THE NORTH RANCH

A SUBDIVISION OF A PORTION OF SW 1/4 SECTION 15 AND
THE SW 14 SECTION 22, T 11 S, R 66 W OF THE 6th P.M.,
EL PASO COUNTY, COLORADO

PAGE 2 OF 3

THE NORTH RANCH
A SUBDIVISION OF A PORTION OF SW 1/4 SECTION 15 AND
THE SW 14 SECTION 22, T 11 S, R 66 W OF THE 6th P.M.,
EL PASO COUNTY, COLORADO

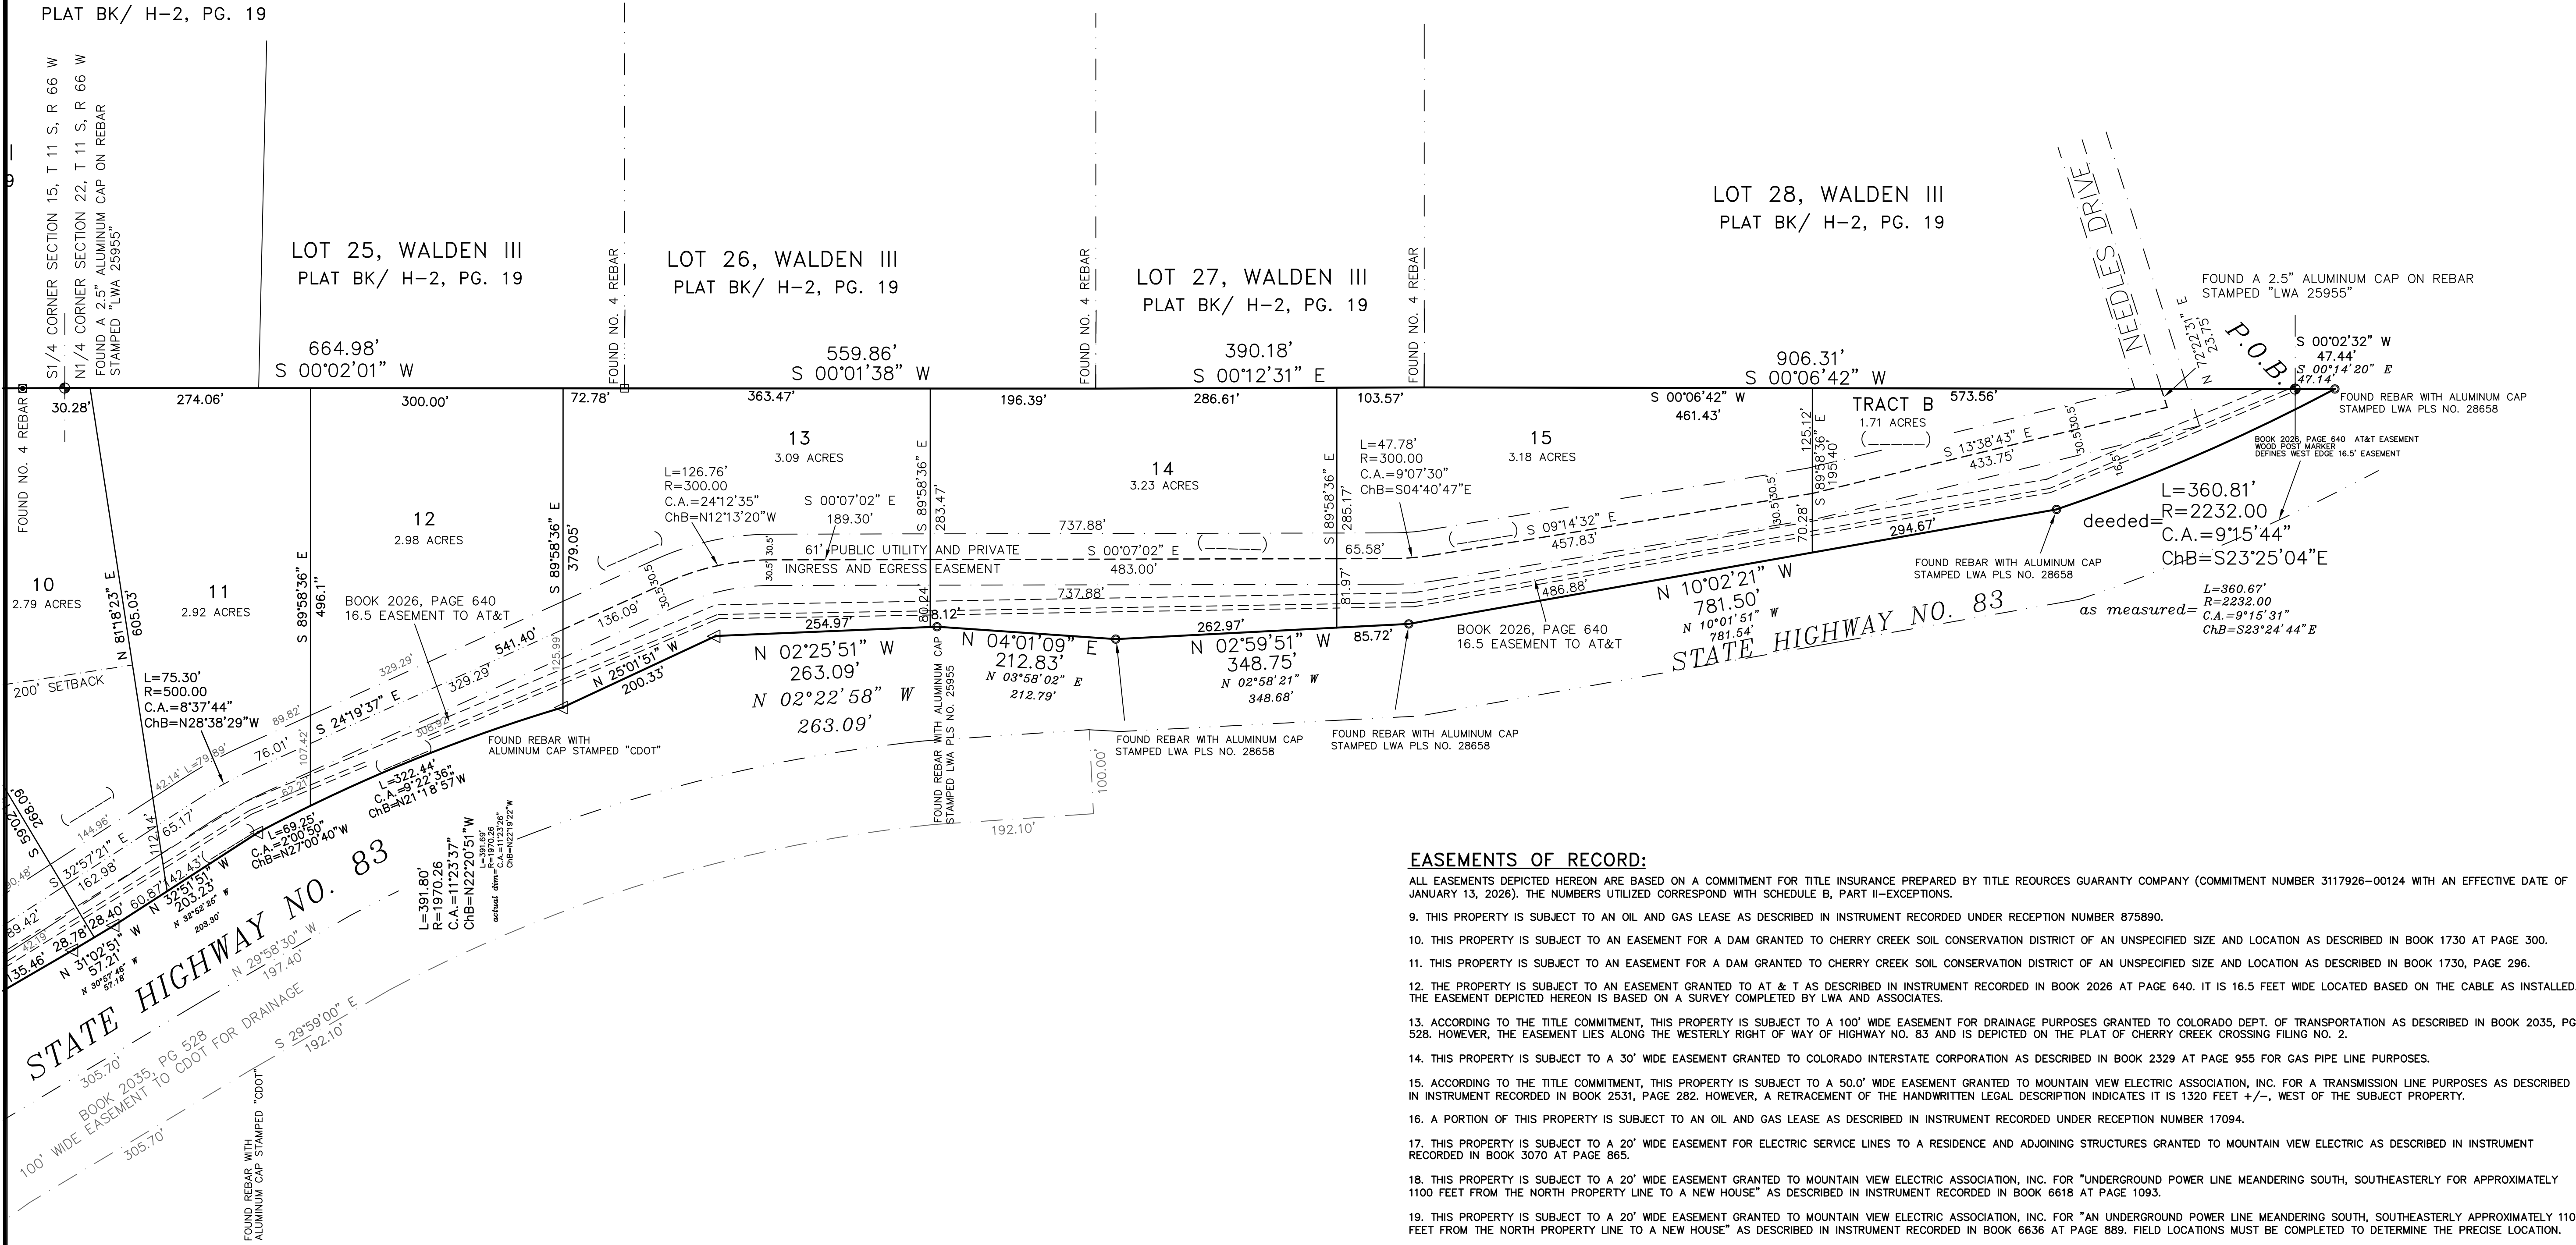
minimum radius will be
reviewed when CDs
have been submitted.

show existing easements for temporary turnaround on Needles Dr

label County ROW

a turn around meeting.
EPC standards will be
required at the
transition from public to
private road
